Acoustic Expert Report
Of
Ian MacArthur
Clarke Saunders Associates

THE PLANNING ACT 2008 PINS Ref: EN010168
Application by Lime Down Solar Park Limited for an Order granting
Development Consent for the 'Lime Down Solar Project'

SLD Wiltshire Limited

Title: **Figure 14-1-1: Noise Monitoring and Sensitive Receptor Locations**

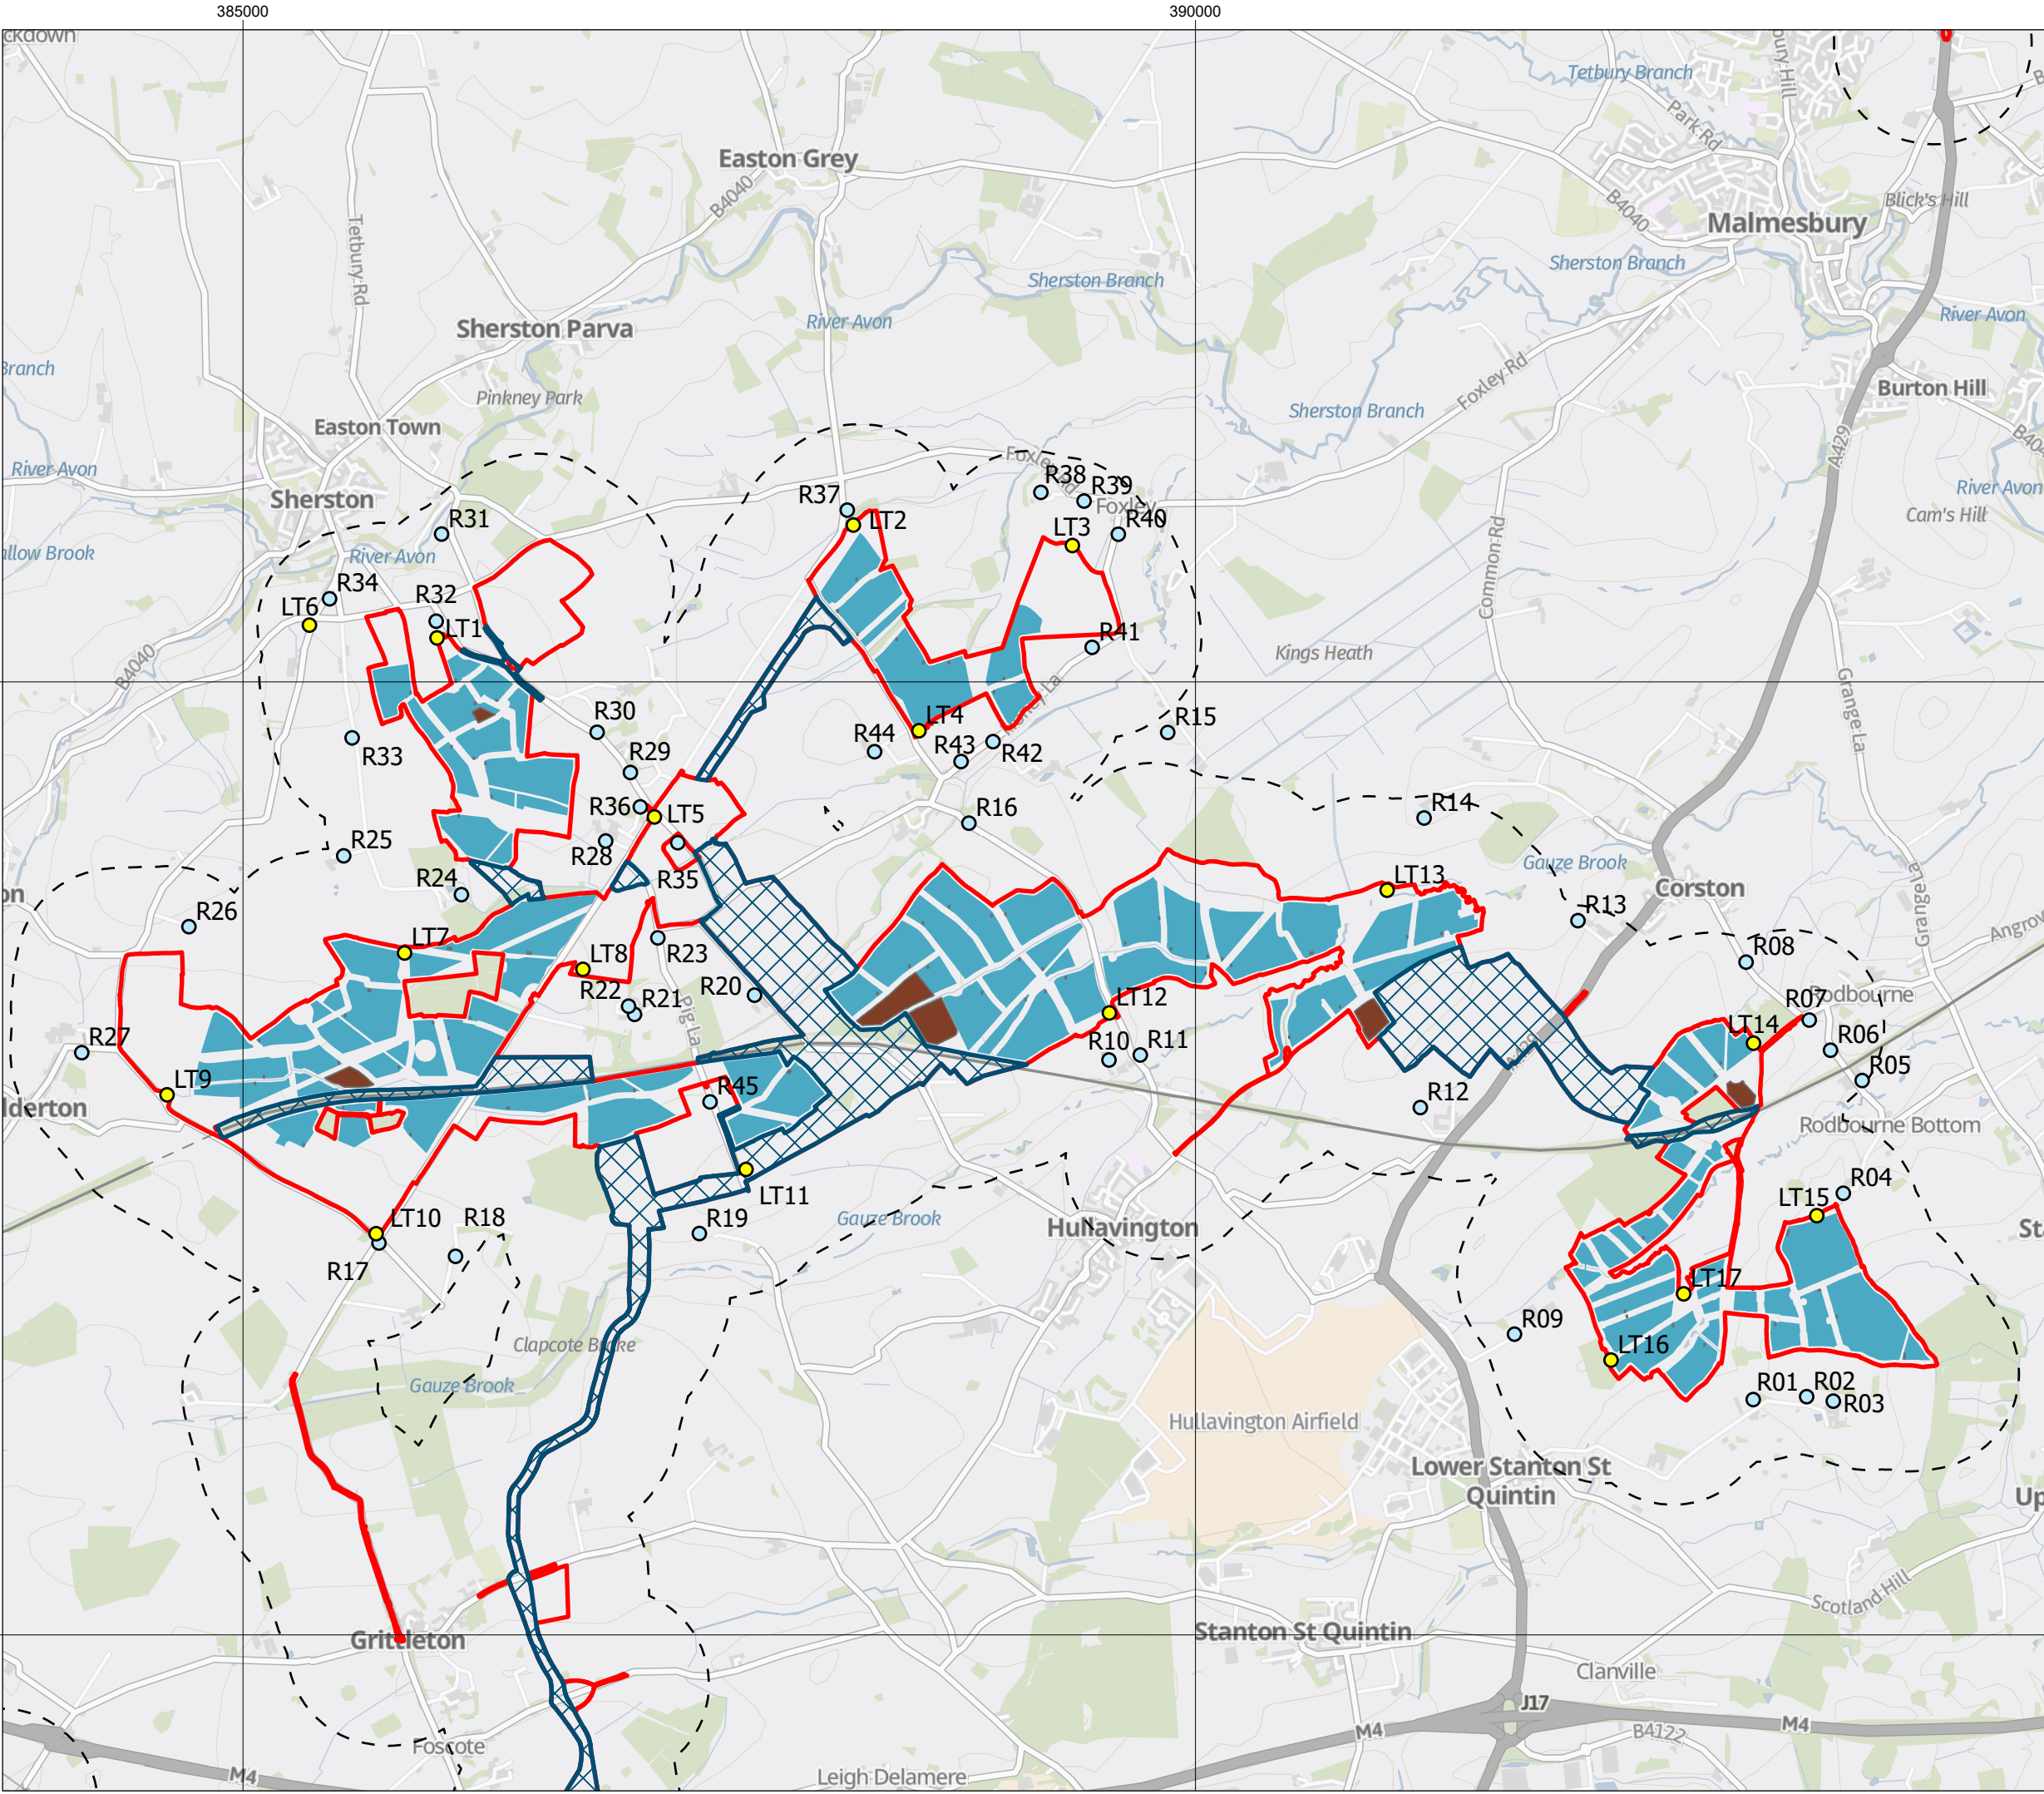
- 5.4 This monitoring location LT8 has been assigned as being representative of conditions at receptor R20, which is subject to some of the highest predicted noise levels from the development. This sensitive noise receptor is Townlease Farm, comprised of an operational farm and dwelling (see ES at para 14.6.40), located approximately 1km from the indicated location of the noise monitor.

- 5.18 The Applicant’s background noise surveys used a monitor installed at location LT12 to inform the baseline levels at Bradfield Manor (receptor R10). Bradfield Manor is a particularly sensitive receptor, being both a residential dwelling but also a Grade I listed heritage asset.
- 5.19 This monitoring position is shown to have been located very close to the road (Bradfield Cottages), which would therefore measure significantly higher average and maximum noise levels from road traffic than would be

experienced at Bradfield Manor, which is situated at least 100m from the road. Such a selection of location fails properly to consider BS4142:2014 which provides that, where assessment at the relevant assessment location is not possible, “measure at an alternative location where the residual sound is comparable to the assessment location(s)” (para 8.1.2).

- 5.31 The majority of monitoring locations were located in relative close proximity to roads. The monitoring positions not in close proximity to roads, for example LT3, showed low average L_{Aeq} levels ranging between 35-45 $dBL_{Aeq,T}$ during the daytime. This is representative of ambient L_{Aeq} levels away from transportation networks, as would be the case for the majority of bridleways and the ProW network in the area.

Title:Figure 14-02:
Daytime Operational Noise Contours

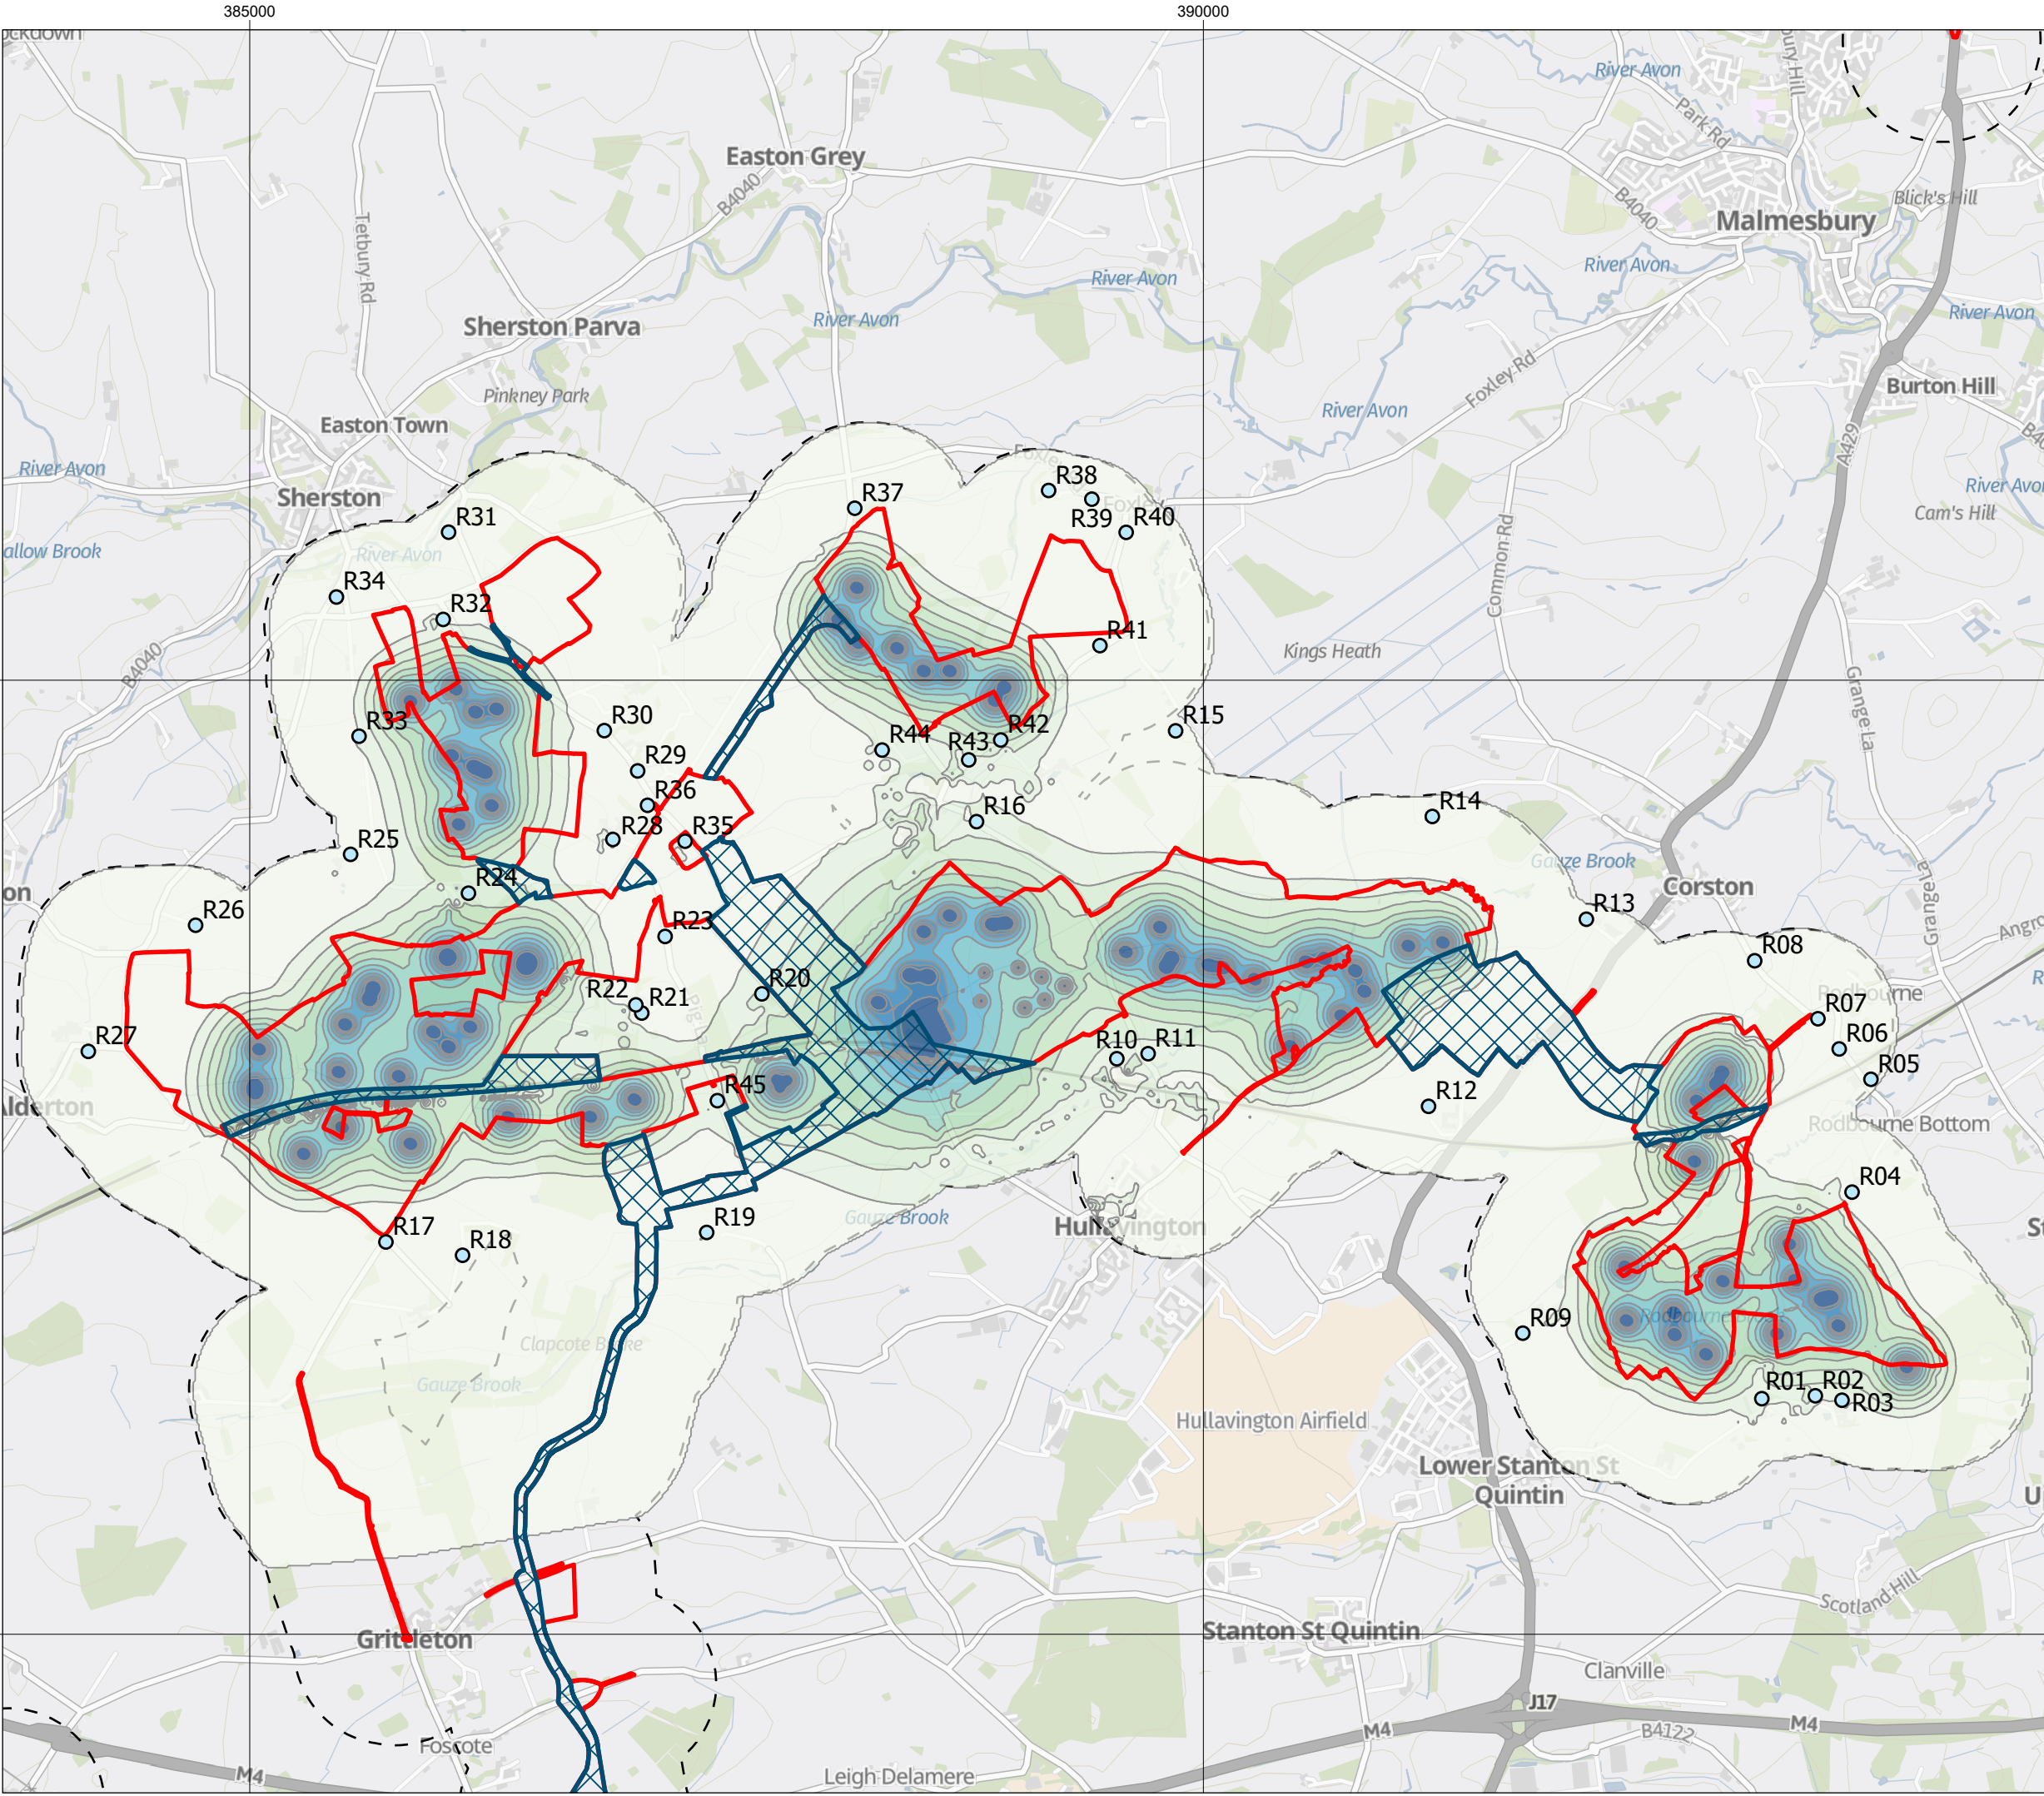
- 5.38 Noise levels over 50dB_{L_{Aeq}} from the development would therefore fall into the category of ‘moderate annoyance’, if compared to this guideline, and, as levels could be significantly above the ambient L_{Aeq} levels, would not satisfy the guideline to preserve the currently low ratio of intruding noise to natural background sound.
- 5.39 An overlay of the ProW network on the proposed daytime noise contours (limited to 50dB_{L_{Aeq}}) is shown in the figure below. This figure is also included as Annex A to this report.

- 5.40 From analysis of this figure, the following eleven bridleways, footpaths or byways have initially been identified as being subject to plant noise levels over 50dB_{L_{Aeq}}: SHER16, NORT1, SHER18, LUCK57, NORT1, 10, HULL 1,2,4,5,6,7 and MALW59.
- 5.41 The project area falls within an area on the boundary of the Cotswolds National Landscape and has a high valued tranquillity score identified by the CPRE mapping⁷. A number of these routes are also likely to be part of routes that those travelling to and from the National Landscape may use.
- 5.42 The National Planning Policy Framework (NPPF) echoes the NPS-EN-1 policy regarding recreational areas at paragraph 198:
